Appeal Decision

Appeal Ref: 6001832

1A Roseville Road, Hillingdon, Hayes UB3 4QX

- The appeal is made under section 78 of the Town and Country Planning Act 1990 (as amended) against a refusal to grant planning permission.
 - The appeal is made by Mr Maneet Singh Batra against the decision of the Council of the London Borough of Hillingdon.
 - The application Ref is 1142/APP/2025/1826.
 - The development proposed is a 1st floor side and part rear extensions.
-

PROPOSED SIDE ELEVATION 1

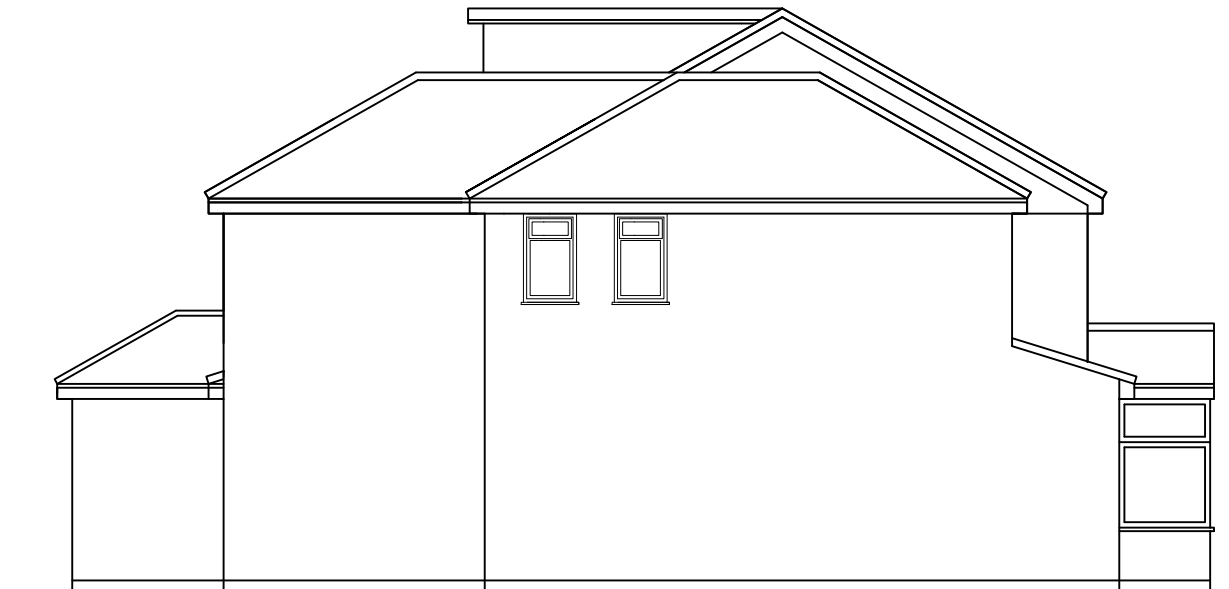
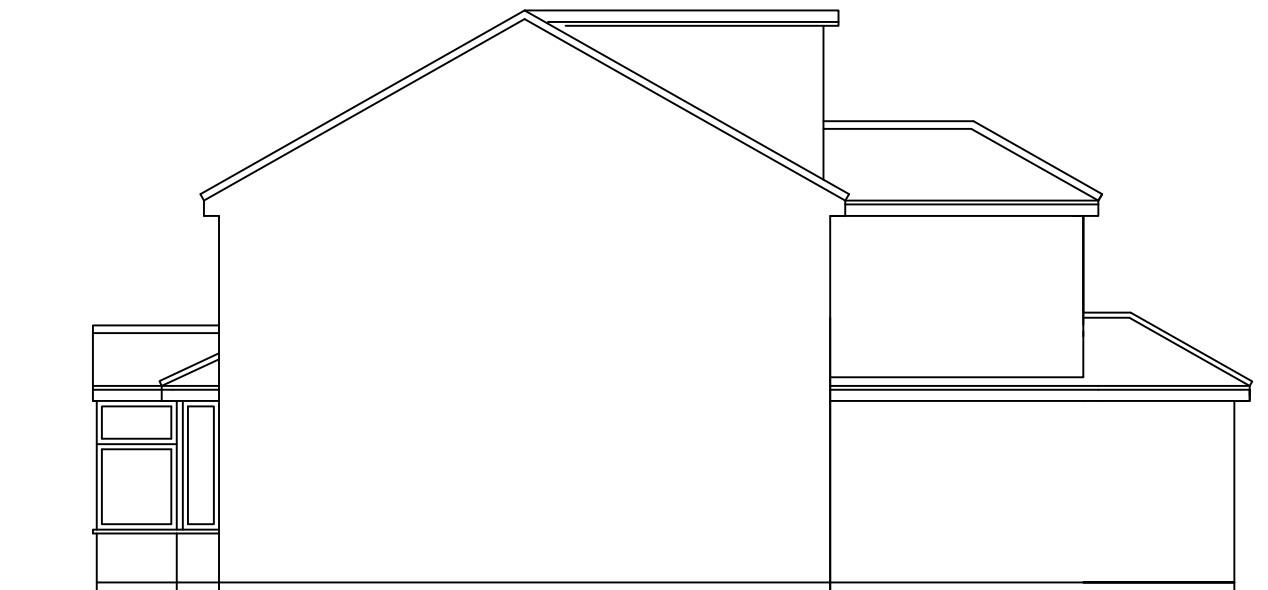
5. At ground-floor level, the existing side projections at both the host property and the neighbouring dwelling (No. 2) currently preserve a sense of separation between the two houses at first floor level. The proposed extension would substantially erode this visual gap. Even though the buildings would not physically connect, the reduced spacing would create the impression of a continuous frontage, shifting the appearance from the established open, semi-detached rhythm of the street toward something more akin to a terraced form.

6. The host property has been extended several times previously, including a ground-floor side and rear extension, a first-floor rear extension, and a hip-to-gable conversion with a rear dormer. These cumulative alterations have noticeably increased the scale and massing of the dwelling. Introducing further built form

would intensify this effect, resulting in a property that appears disproportionately enlarged and overdeveloped.
